WEST SUSSEX COUNTY COUNCIL CONSULTATION

TO:	<u>Arun</u> District Council <u>FAO:</u> Mrs. A. Gardner
FROM:	<u>WSCC</u> – County Highways Authority: Tim Townsend
DATE:	6 th September 2019
LOCATION:	Land At <u>Toddington</u> Farm North And West Of 1 To 3 <u>Toddington</u> <u>Toddington</u> Lane <u>Littlehampton</u> <u>BN17 7PN</u>
SUBJECT:	<u>LU/248/19/DOC</u> Approval of details reserved by condition imposed under ref APP/C3810/W/18/3197149 (LU/162/17/PL relating to Condition Nos 8 - materials & finishes, 9 - landscaping scheme, 10 - Construction Management Plan, 13 - visibility splays, 14 - pedestrian visibility plays, 16 - cycle parking and 18 - street lighting.
DATE OF SITE VISIT:	n/a - for purposes of this specific planning application.
RECOMMENDATION:	More information required
S106 CONTRIBUTION TOTAL:	n/a for purposes of this specific planning application.

This is the WSCC County Highways (CHA) response to the above planning application for approval of details reserved by condition imposed under ref APP/C3810/W/18/3197149 (LU/162/17/PL relating to Condition Nos 8 - materials & finishes, 9 - landscaping scheme, 10 - Construction Management Plan, 13 - visibility splays, 14 - pe

Proposed Garden Shed - 1:50 @ A1
(secure cycle storage)

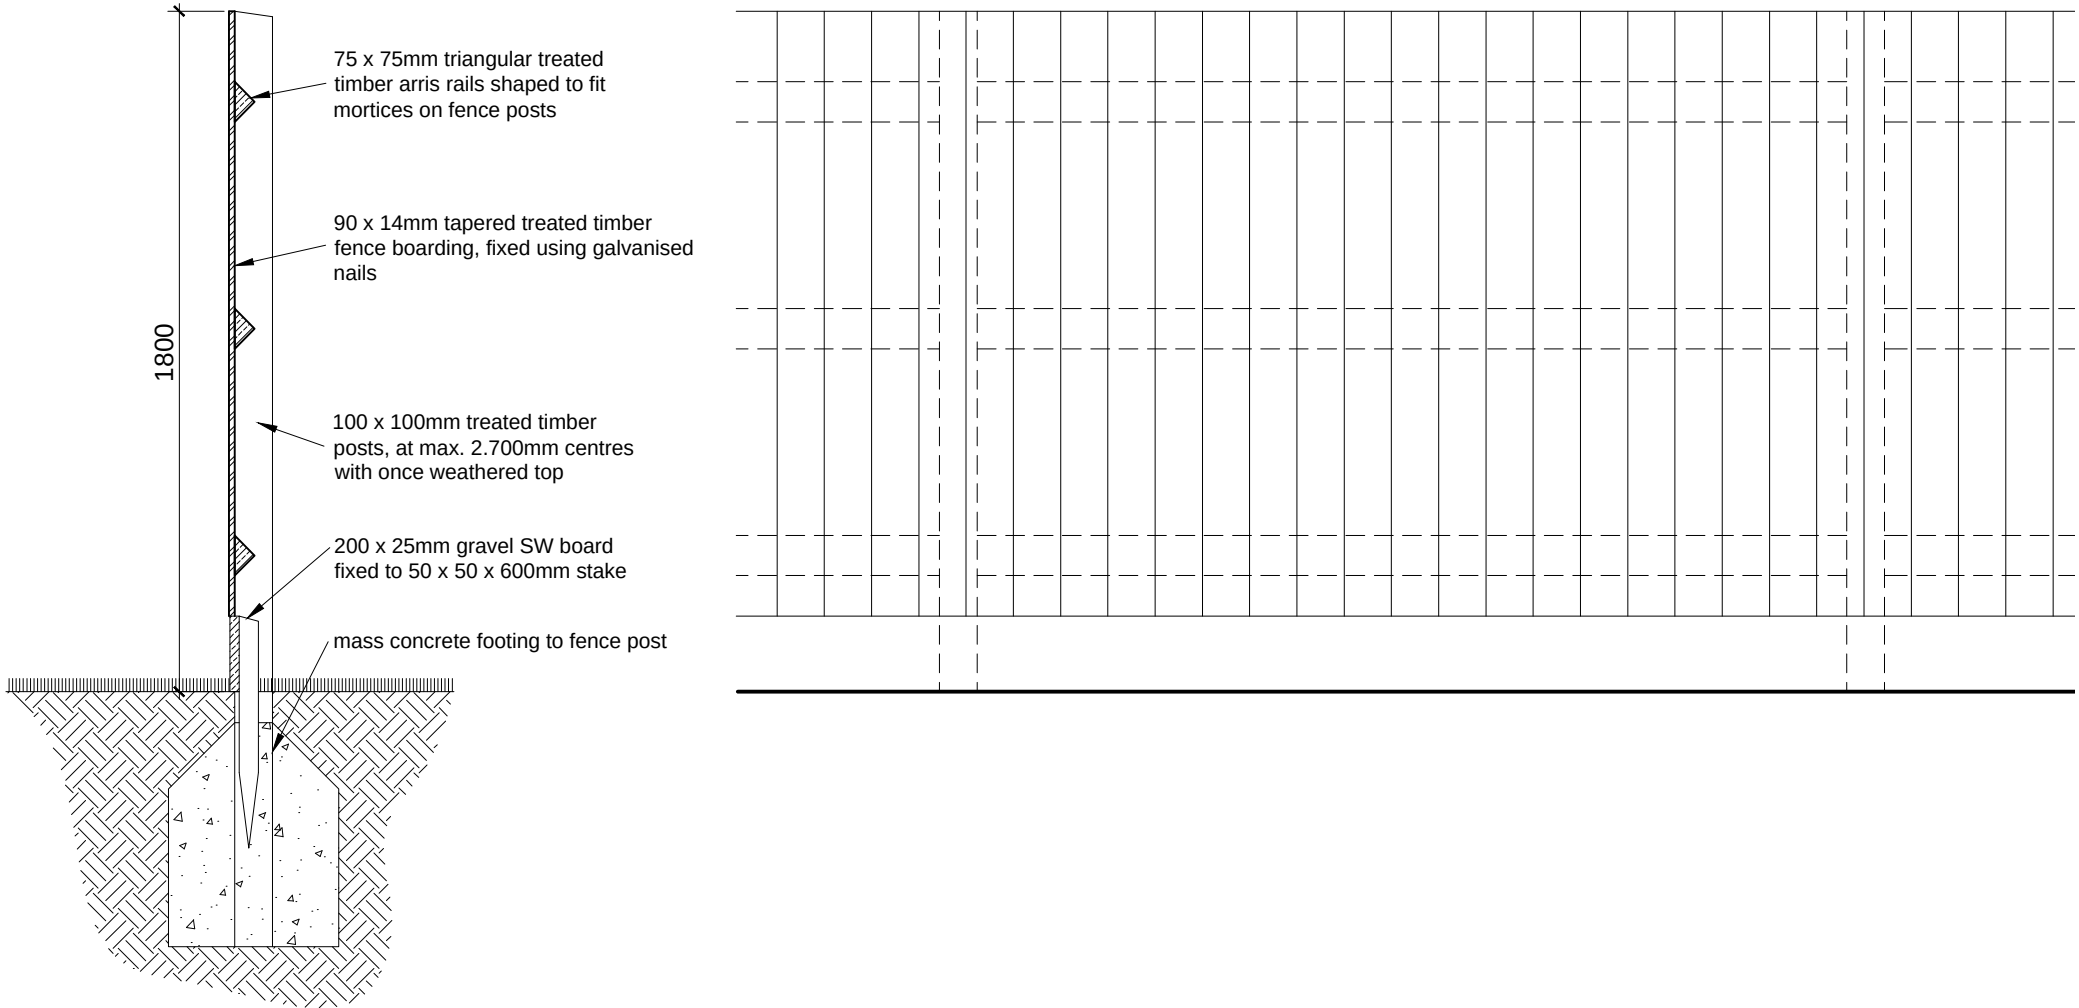
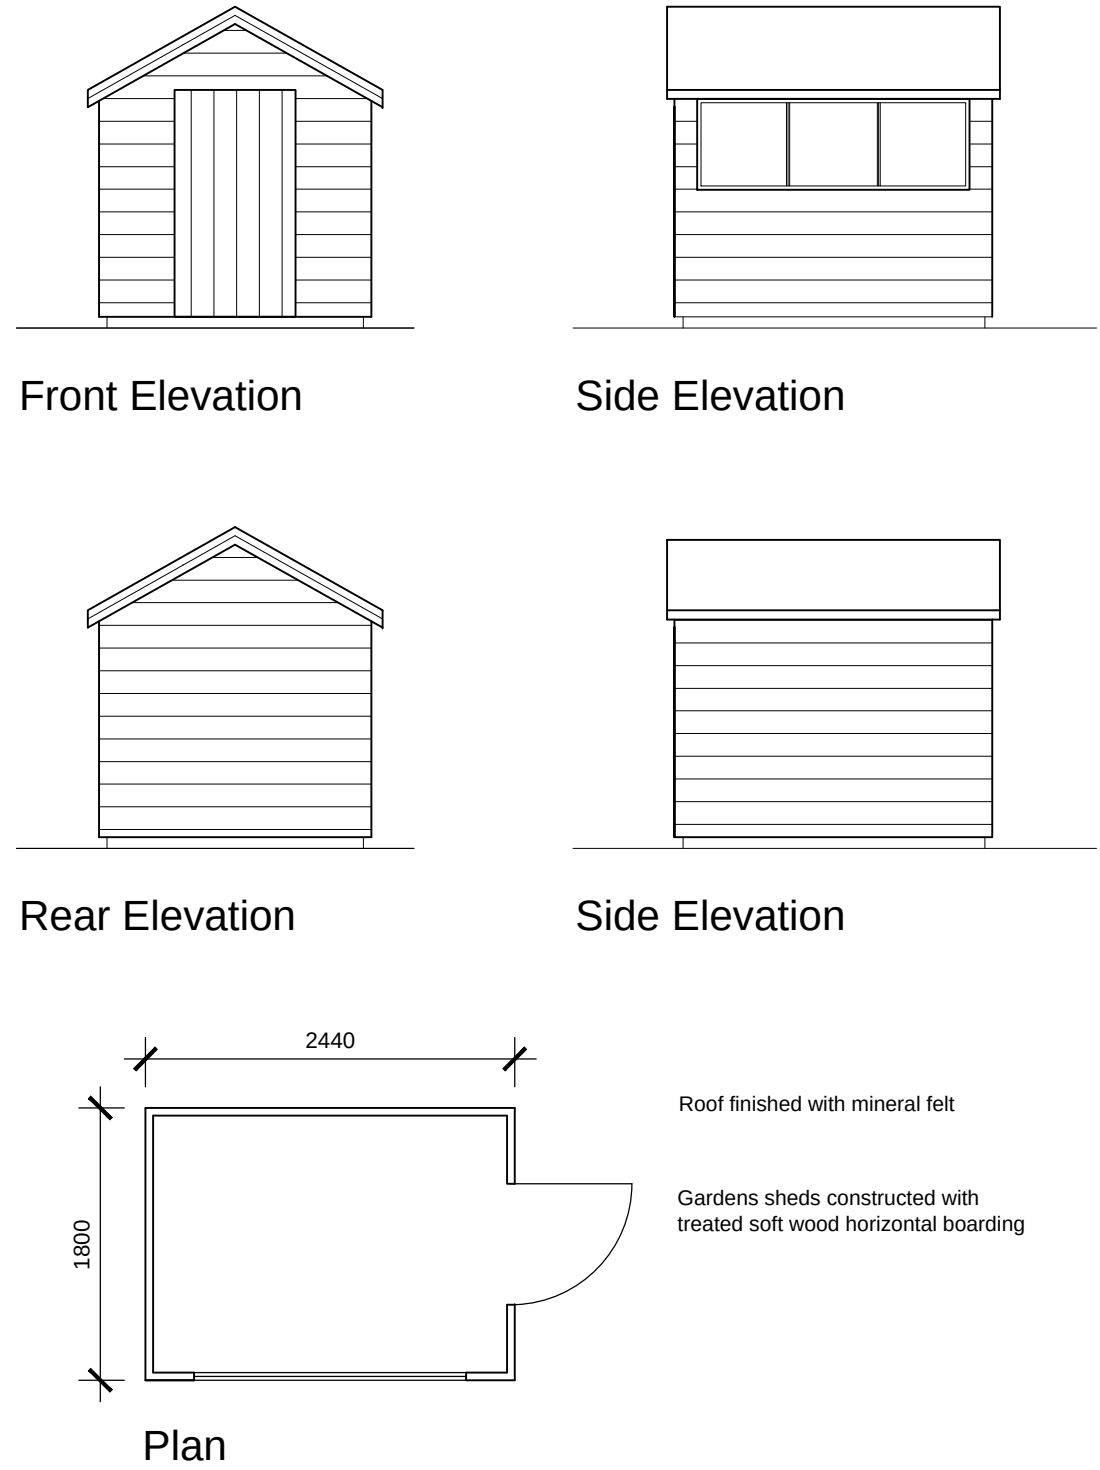
6. Condition 16 (cycle parking) – Generally acceptable. However, access for plot 6 is not shown and access to shed to rear of plots 4/5 appears somewhat restricted. Shed would benefit from being moved slightly further westwards away from the access gate.

Drawing Title:
Detailed Planting Plan

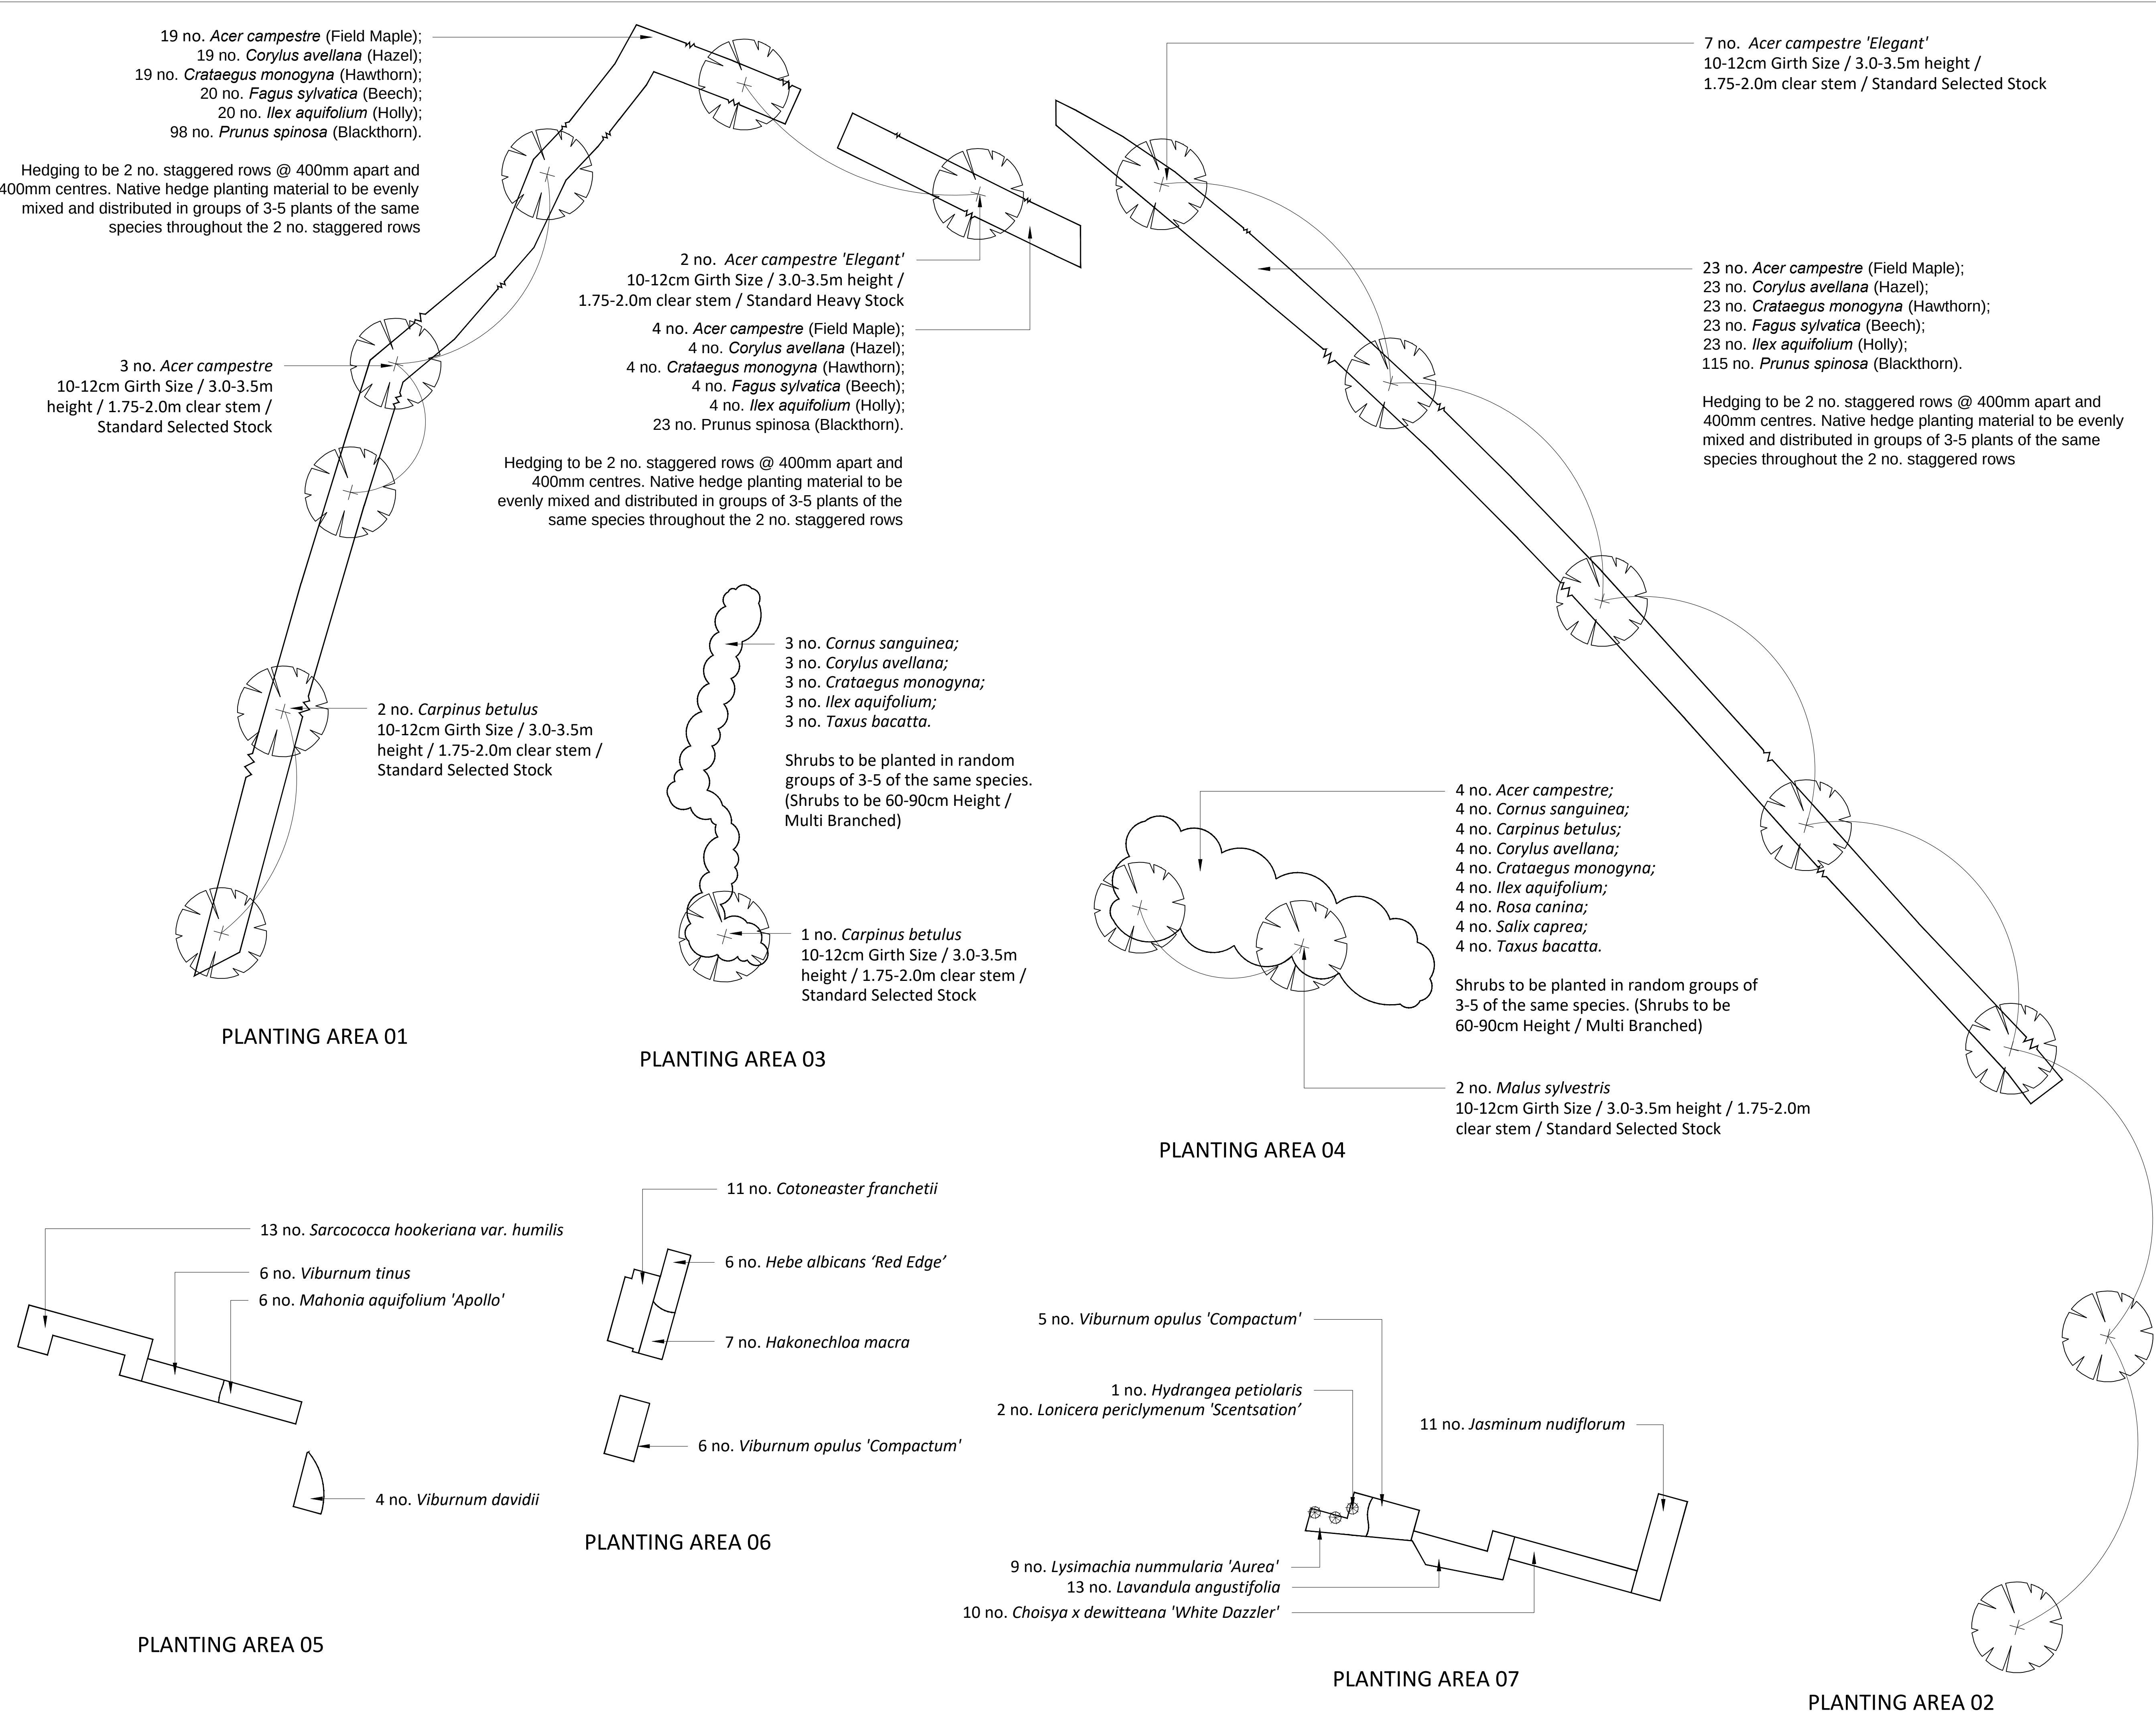
2. Condition 9 (landscaping) – The proposed species for the hedgerow and trees adjacent to the footway are suitable and characteristic of a more rural location, despite the increasing housing development in the vicinity. The trees are a more compact form of field maple and a medium sized tree at maturity. However, it is preferable to adjust the species mix of the hedge, reducing the blackthorn component, increasing the hawthorn component and removing the beech so that the mixture is along these lines: 60% hawthorn; 4 x 10% minor species.

There is conflict between the lighting column plan and the planting plan – in places, columns are shown right next to trees so this needs adjustment. Similarly, all drainage and

ducting for services MUST not conflict with the planting to avoid damage if repairs / replacement is needed in future.

A long term maintenance plan for the planting should form part of the planning consent.

Details of what edge restraints are proposed for the footway to be provided. Is a fence proposed behind the hedge or in front of it? Ideally not, but a temporary one may be necessary to protect the planting as it becomes established.

Finally, there does not appear to be any reference to protection for the hedging/shrubs – are shrub shelters/stakes/other guards proposed?

Please note that much of the planting shown on the drawing would be on land currently forming part of publicly maintainable highway. Therefore, if found to be acceptable, commuted sums would be required for long-term maintenance.
